**A1 IN NORTHUMBERLAND: MORPETH TO ELLINGHAM WRITTEN REPRESENTATIONS FOR DEADLINE 2 AND 3**

**A1 IN Northumberland: Morpeth to Ellingham DCO Application Planning  
Inspectorate Reference: TR010059**

**Summary of Written Representations  
On behalf of the Environment Agency (EA)**

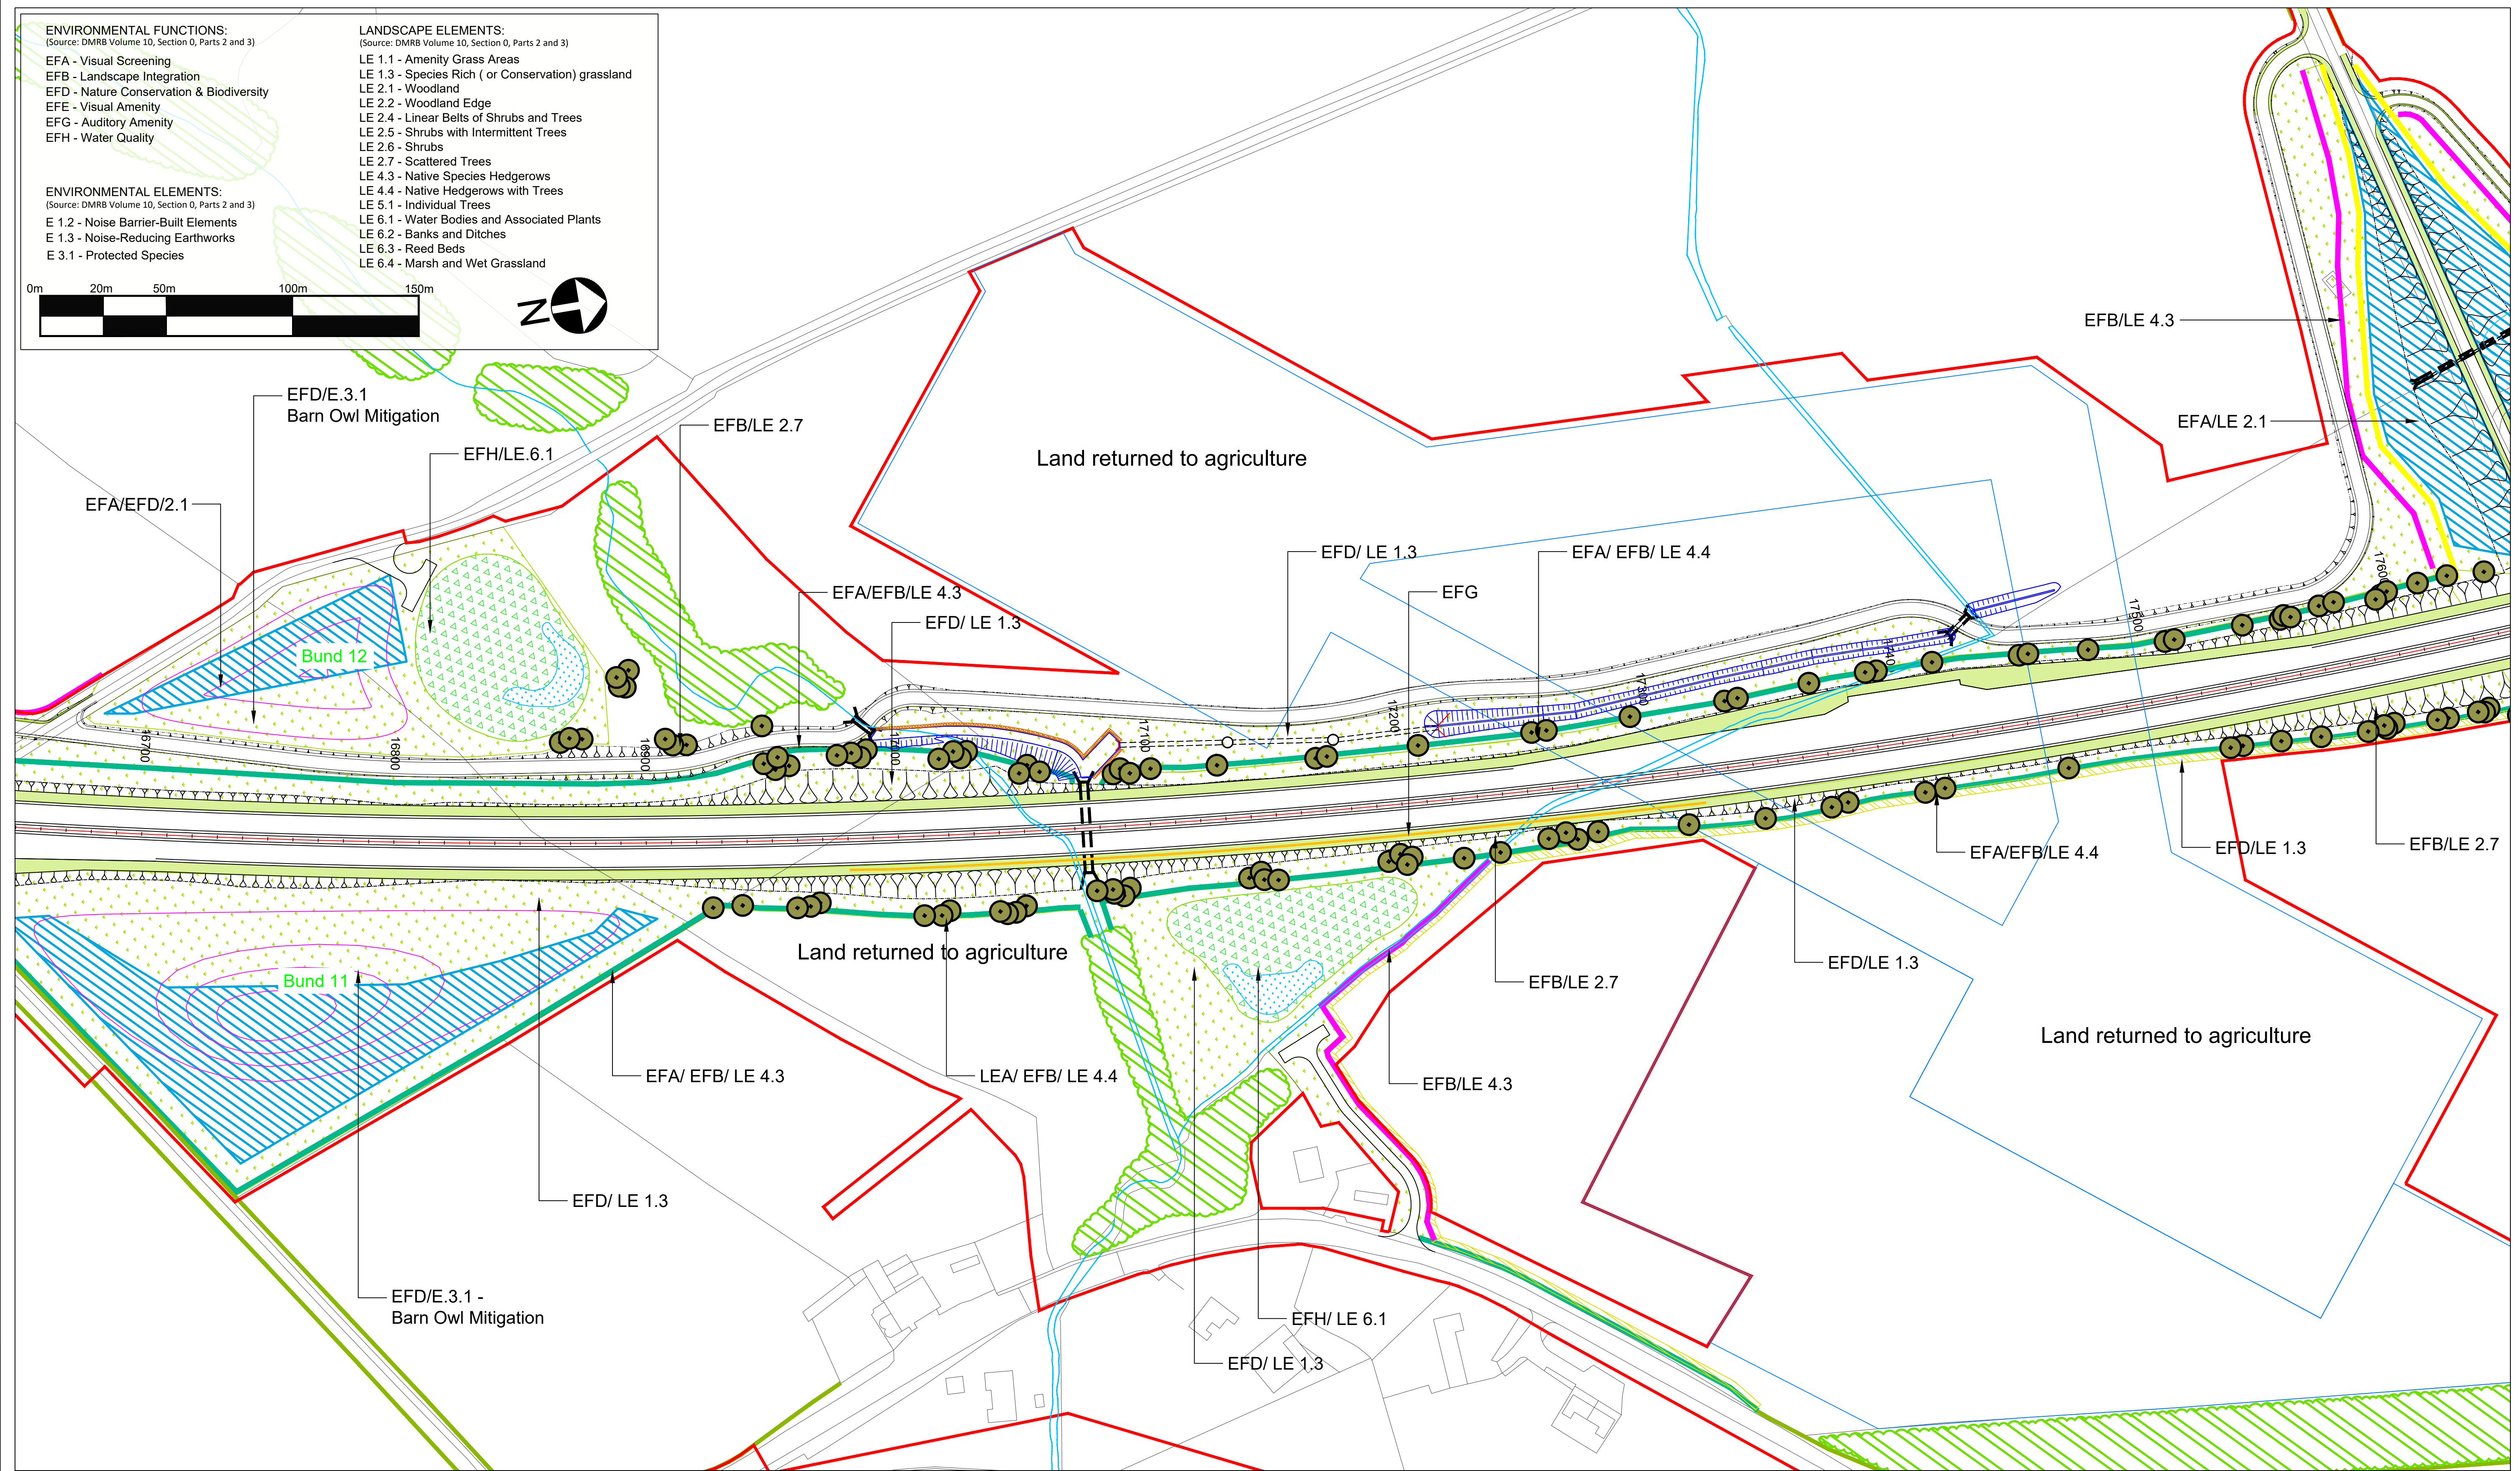
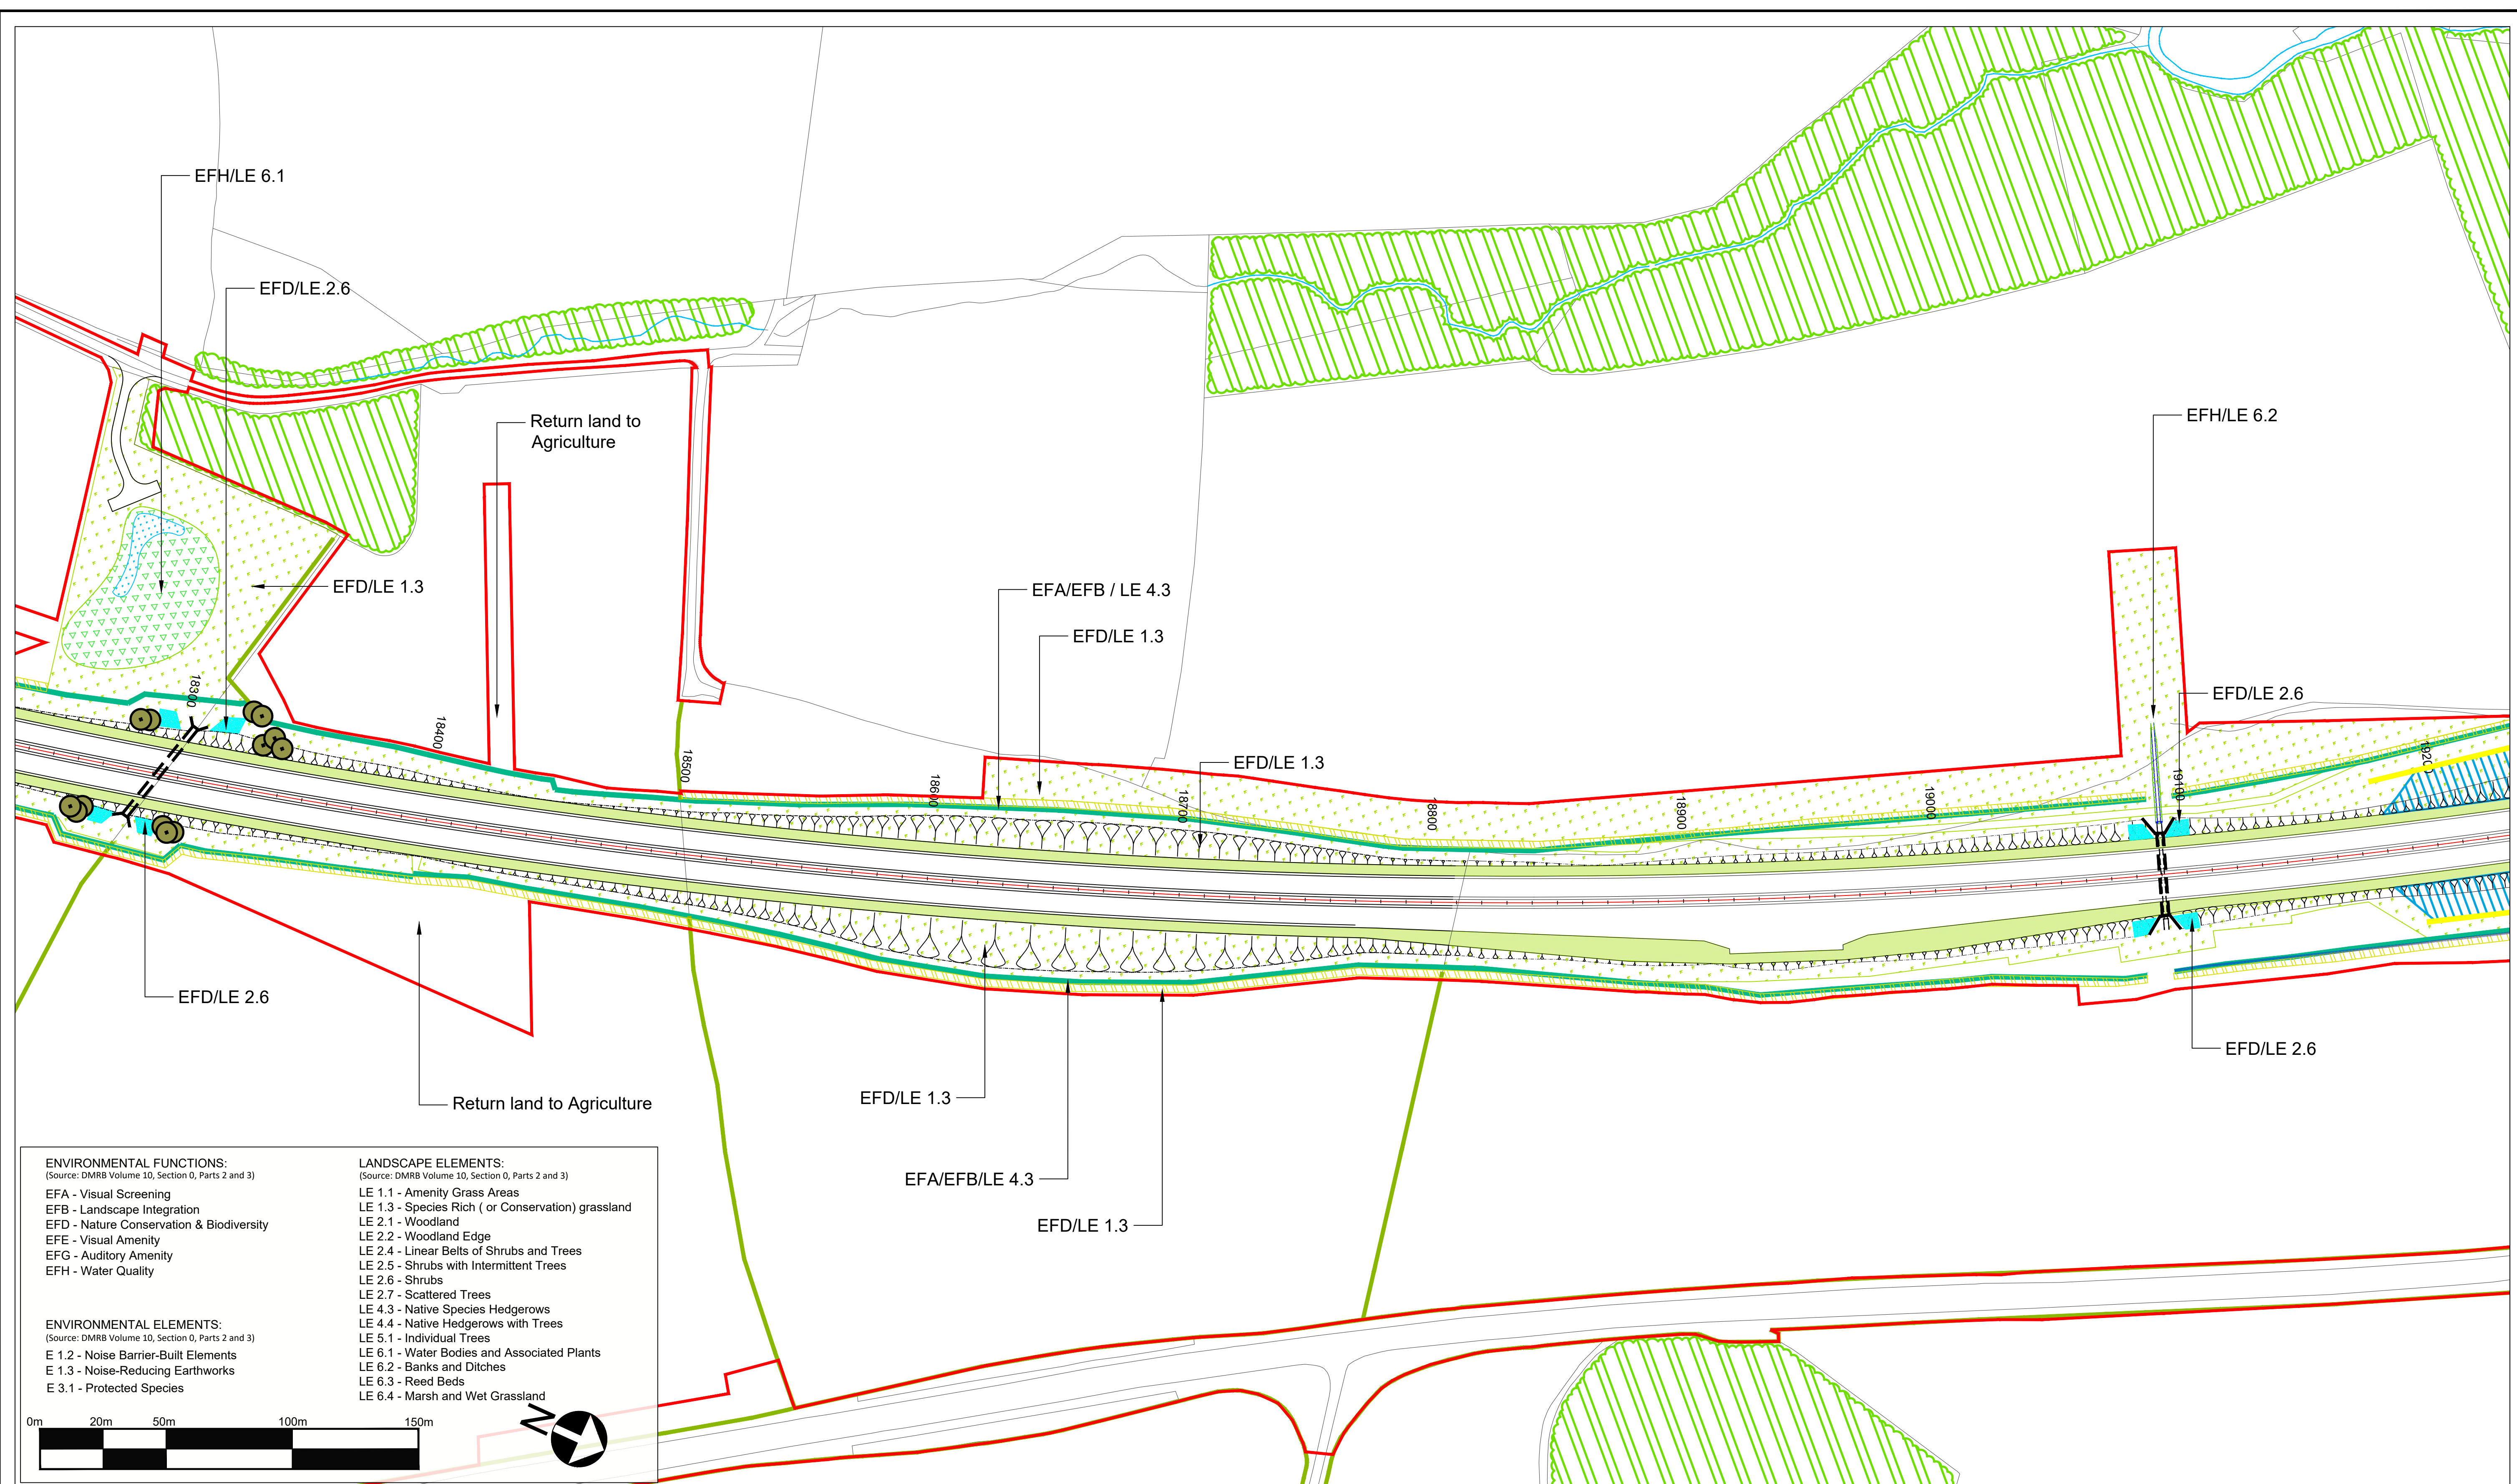
The applicant needs to provide compensation for the loss of watercourses and habitats, which is not evident in the culvert mitigation strategy or the Outline Construction Environmental Management Plan (CEMP) - Rev 2 [REP3-013]. The mitigation strategy states large areas of wet woodland will be created which we believe is an incorrect definition of the habitat created and should be reclassified as riparian woodland, unless it can be clearly demonstrated that wet woodland is being created. We are unable to see the evidence of this and would recommend that these proposals are included in the Landscape Mitigation Masterplan or similar plan.

The mitigation strategy states large areas of wet woodland will be created. We believe this is an incorrect definition of the habitat created and should be reclassified as riparian woodland, unless it can be clearly demonstrated that wet woodland is being created. The areas of 'wet woodland' created appear to align with the comments made in 7.9.1 Appendix A Response to RR-04 Environment Agency [REP1-065] which claim 'c.38ha of wet woodland and c.12ha of wetland marginal planting'. However, we are unable to see the evidence of this and request that these proposals are included in the Landscape Mitigation Masterplan or similar plan.
